Subject: Addendum Letter: Detention Ponds  
Geologic Hazards Evaluation and  
Preliminary Geotechnical Investigation  
Forest Lakes Subdivision (Phase 2)  
El Paso County, Colorado  
Project No. CS18916-105

CTL | Thompson, Inc. prepared a Geologic Hazards and Preliminary Geotechnical Investigation (Project No. CS18916-105; report dated December 11, 2018) for Phase 2 of the Forest Lakes Subdivision in El Paso County, Colorado. This letter presents our response to El Paso County report review comments related to the three proposed detention ponds that are to be constructed in association with Phase 2.

DESIGNED BY	MAL	SCALE	DATE	10/24/18
DRAWN BY	BB	(H) 1" = 60'	SHEET	13 OF 15
CHECKED BY		(V) 1" = N/A	JOB NO.	1175.21

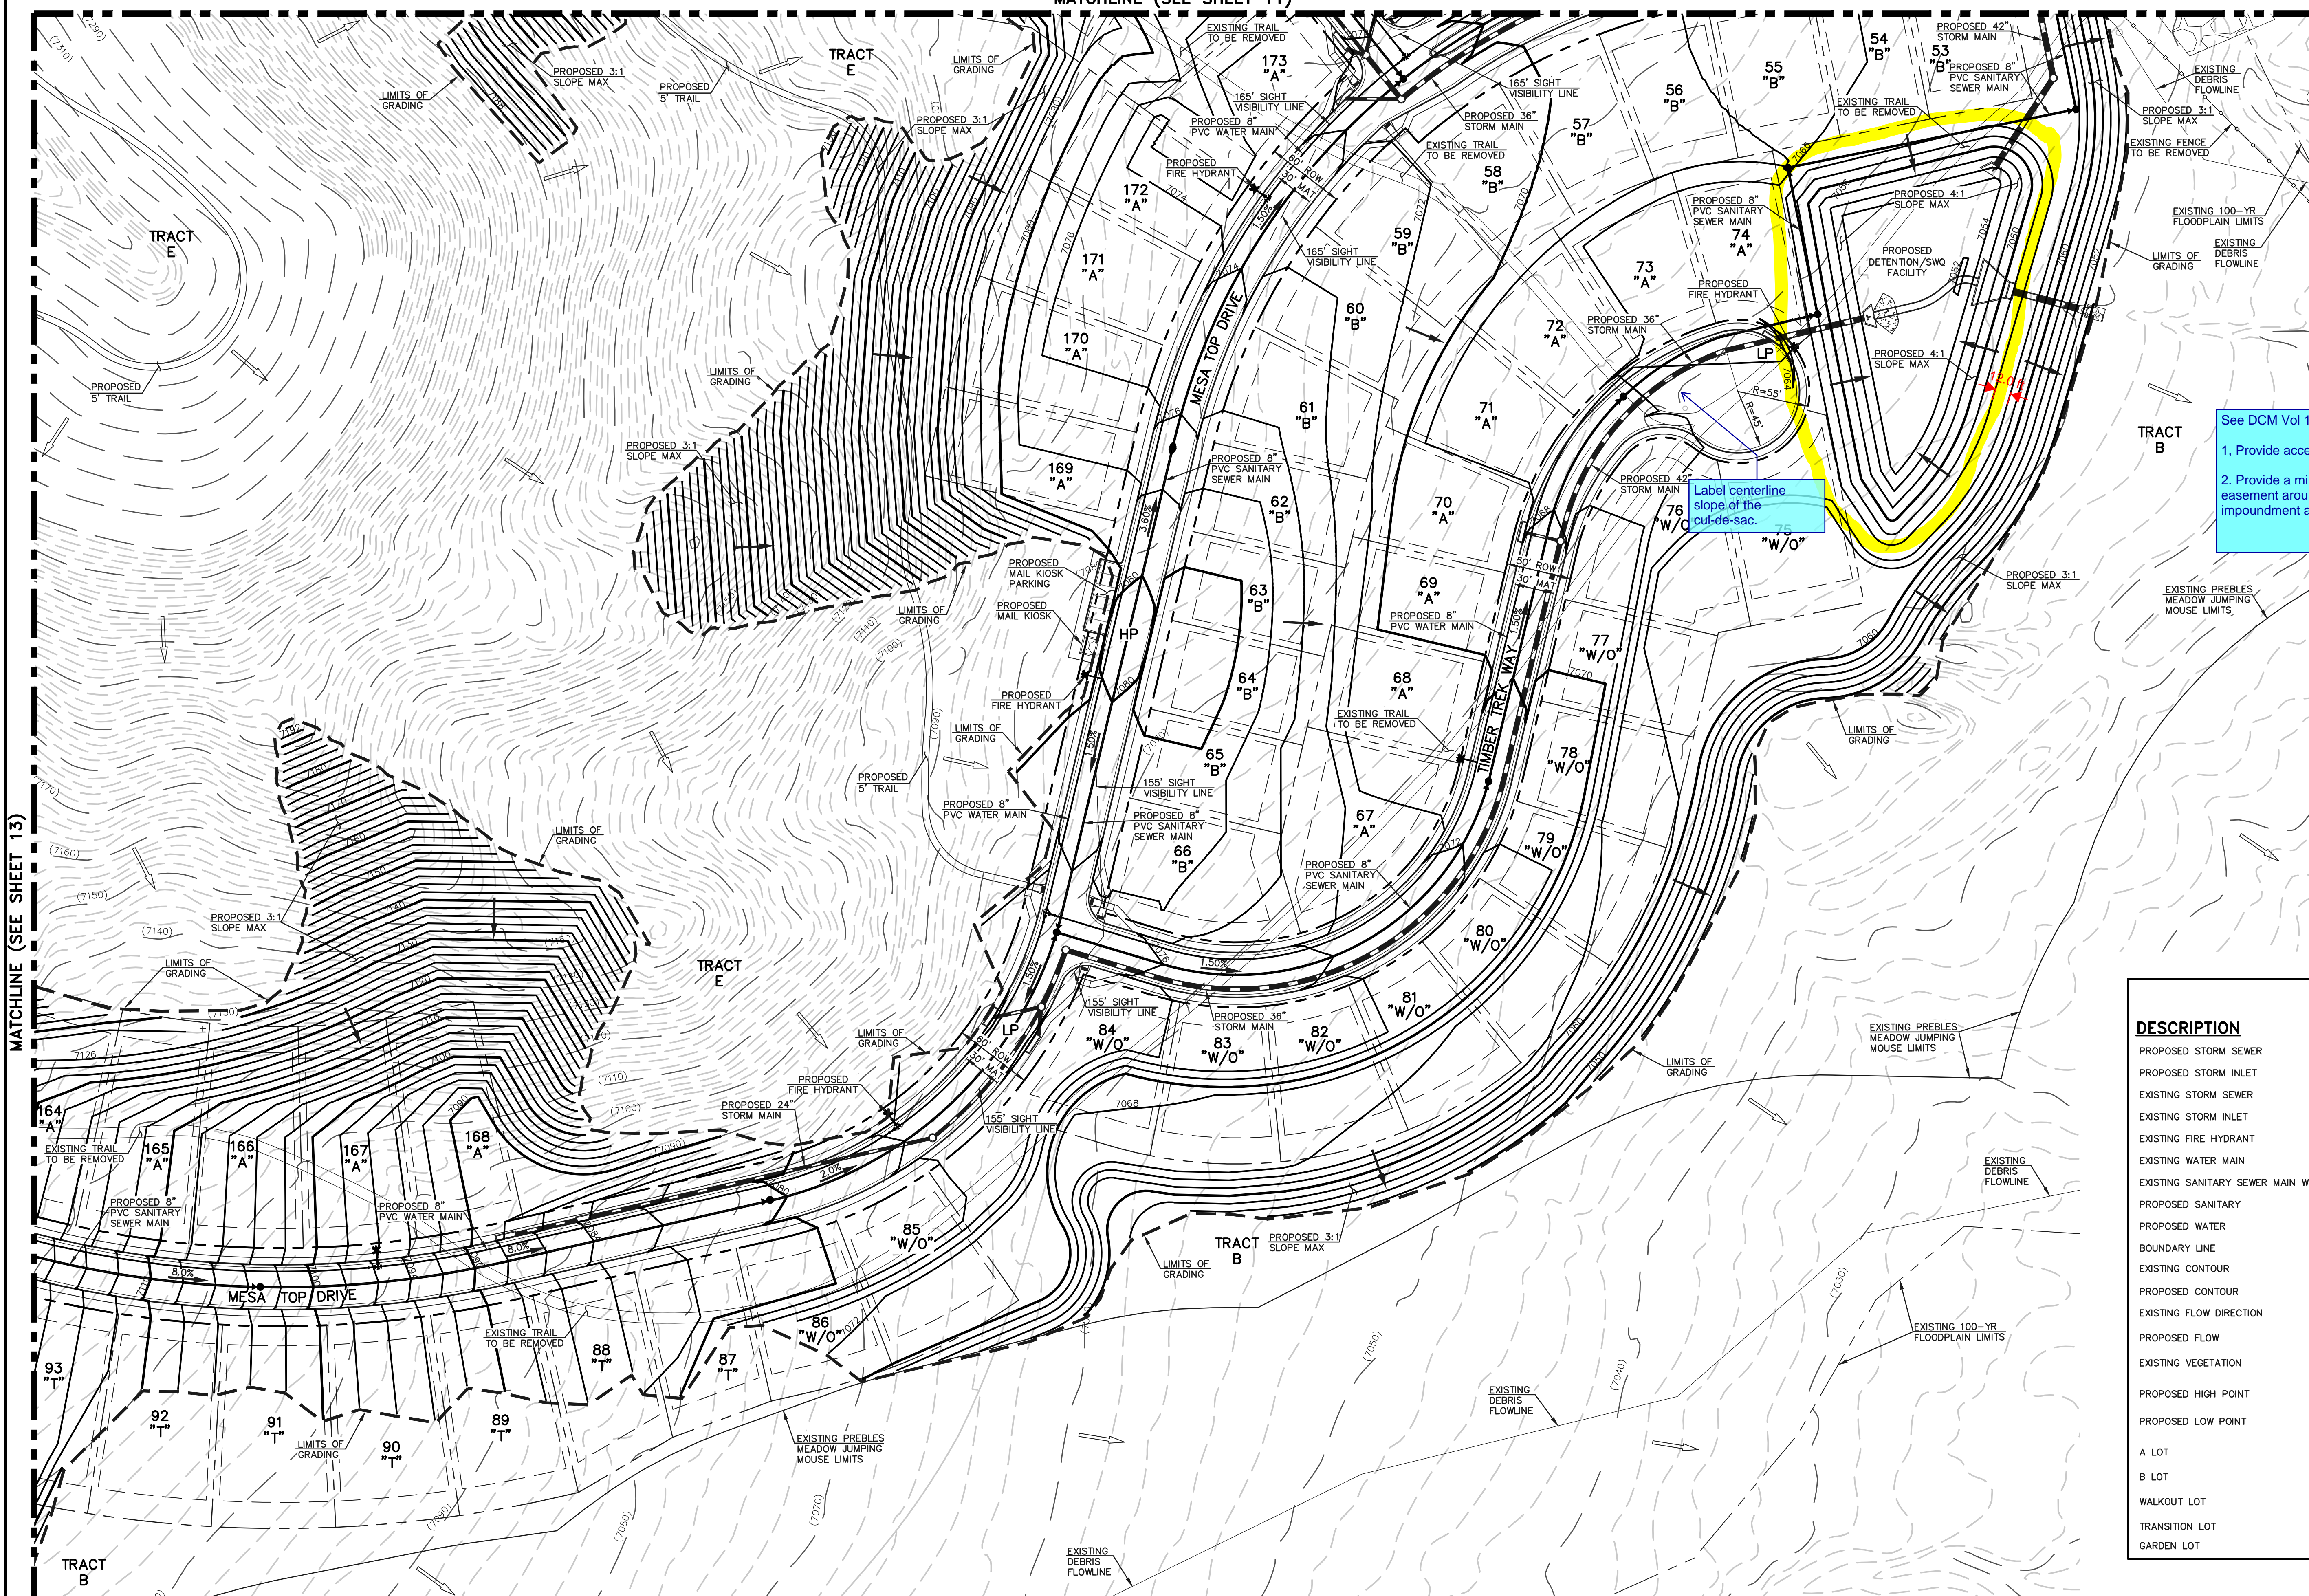
Preliminary Grading and Utility Plans prepared by Classic Consulting (Job No. 1175.21; dated October 24, 2018) were supplied to our office. We recommend the proposed pond embankments have a maximum slope of 3:1 (horizontal to vertical). Granular fill used to construct the embankments should be compacted to at least 95 percent of maximum modified Proctor dry density (ASTM D 1557). Clayey fill placed within the embankments should be compacted to at least 95 percent of maximum standard Proctor dry density (ASTM D 698). The embankment fill should be moisture conditioned to within 2 percent of optimum moisture content. Prior to placement of the embankment fill, existing organic materials and topsoil should be stripped away. The subgrade soils should be moisture conditioned and compacted as specified above to create a firm base beneath the embankment footprint. A representative of our office should be periodically present at the site to observe and test the placement and compaction of the embankment fill materials during construction.
